From: Tom Errico <thomas.errico@tylin.com>
To: Helen Donaldson <HCD@portlandmaine.gov>
CC: David Margolis-Pineo <DMP@portlandmaine.gov>, Katherine Earley <KAS@portlandmaine.gov>, Jeremiah Bartlett <JBartlett@portlandmaine.gov>, Jeff Tarling <JST@portlandmaine.gov>
Date: 5/13/2015 1:12 PM
Subject: 72 Bishop Street

Hi Nell - I have reviewed the application materials and offer the following traffic comments:

Drawing file: 5. Final Approved Plans and Documents / L2_Site Layout.pdf

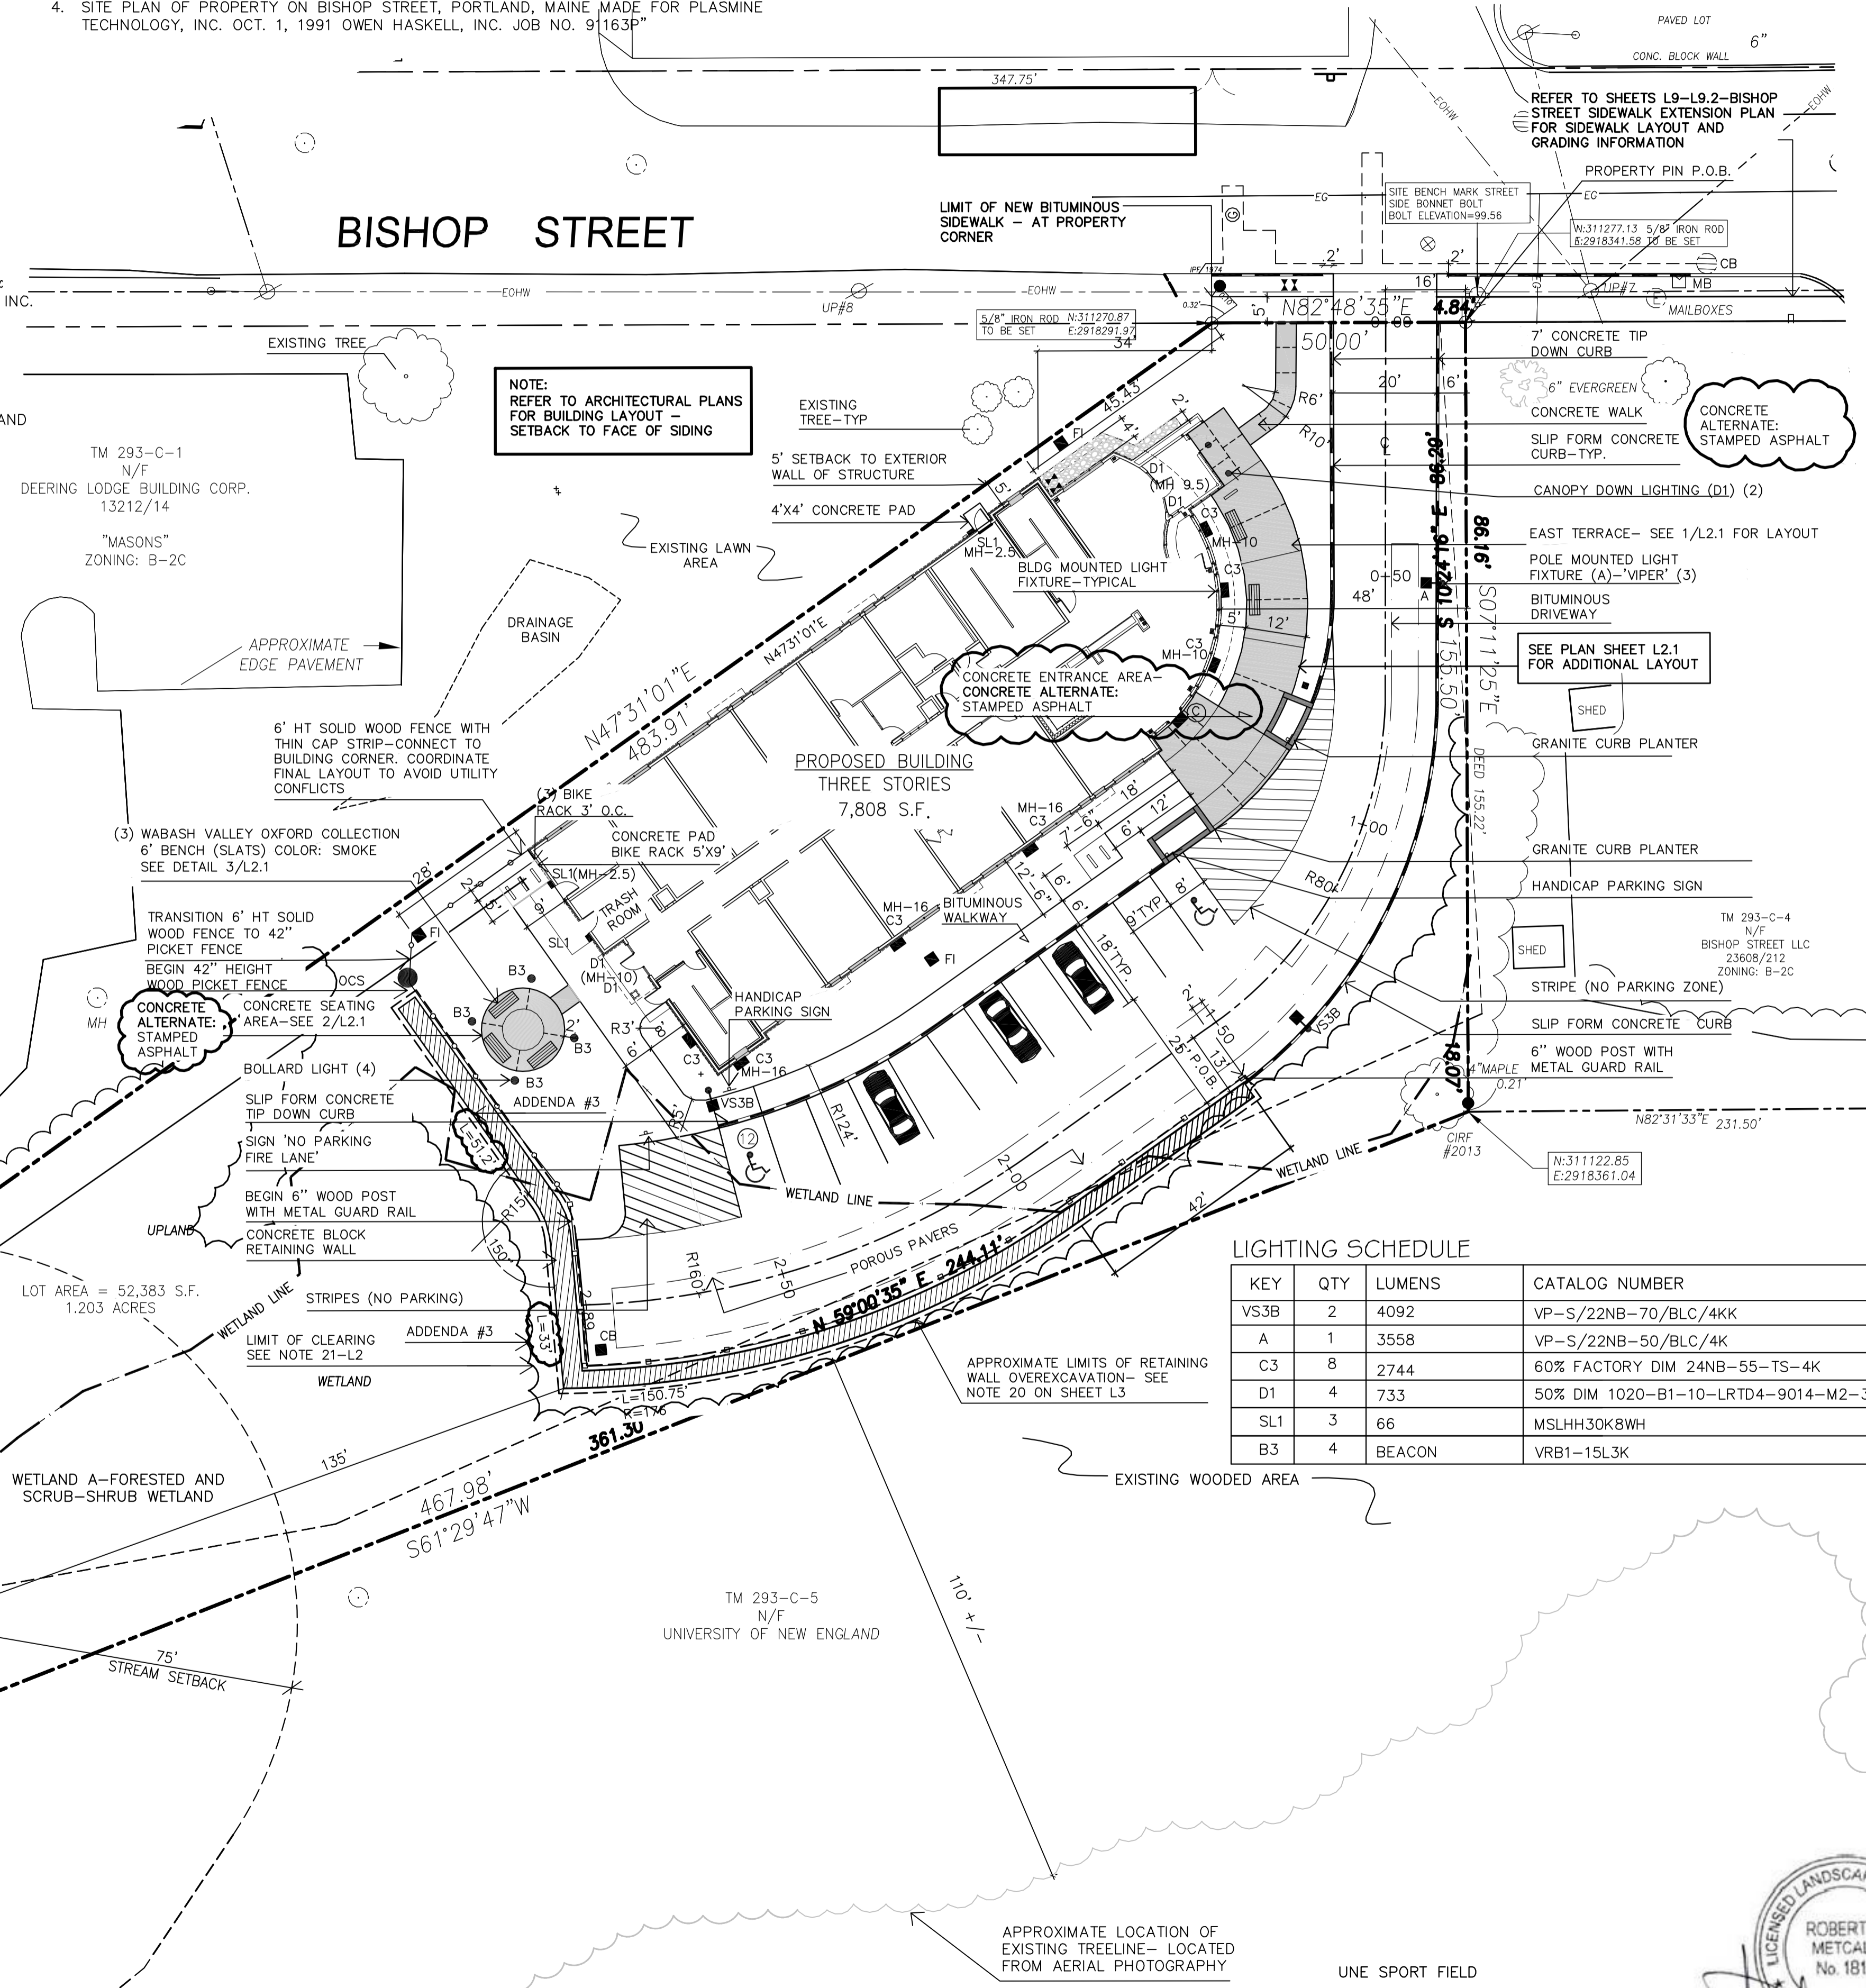
- * I find the parking lot layout and driveway condition to be acceptable.
- * A sidewalk is being constructed on Bishop Street, as identified during the zoning amendment process. I find it to be acceptable although the sidewalk should be extended to the corner at Forest Avenue/Stevens Avenue. I would suggest that the applicant develop a concept plan for review and approval. I can work with the applicant in the development of the plan from a traffic perspective, particularly how it interfaces with the existing parking lot.

- * The applicant has requested a waiver from the City's Technical Standards as it relates to off-street parking requirements. Gorrill-Palmer has provided a summary of parking needs based primarily on staffing requirements. According to the analysis, 12 parking spaces will be sufficient for demand needs. This demand calculation assumes that none of the proposed tenants will be allowed to have vehicles. In general I find the estimate to be reasonable, but I would suggest that a condition of approval note that if automobile ownership is permitted for residents, the project shall return to the Planning Board for review .
